Permit Number: 051387  
OCT 17 2005

to install new windows in rear 5 th flr

**City of Portland, Maine - Building or Use Permit Application**

Location of Construction: 531 CONGRESS ST	Owner Name: HEGA REALTY TRUST	Owner Address: 218 EAST RD	Phone: 2077738499
Business Name:	Contractor Name: Keeley Construction	Contractor Address: P.O. Box 1174 Portland	Phone: 2077738499
Lessee/Buyer's Name	Phone:	Permit Type: Alterations - Commercial	Zone: B3

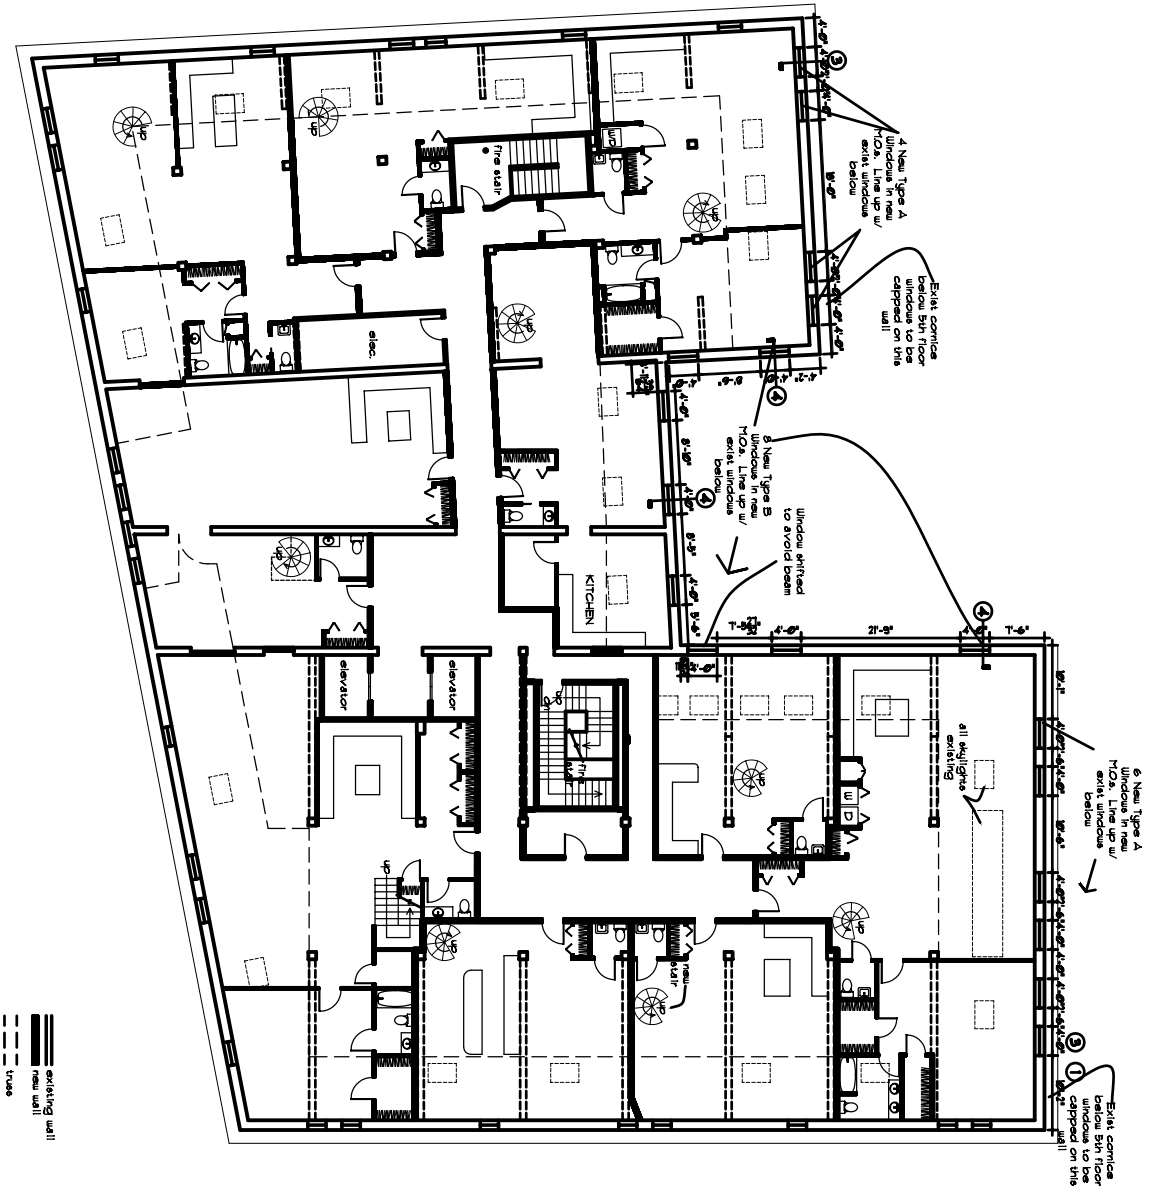
10/13/2005-mjn: have questions, Spoke w/ bill hopkins, need fire separation distance to new windows from adjoining lot lines to establish compliance with Section 704
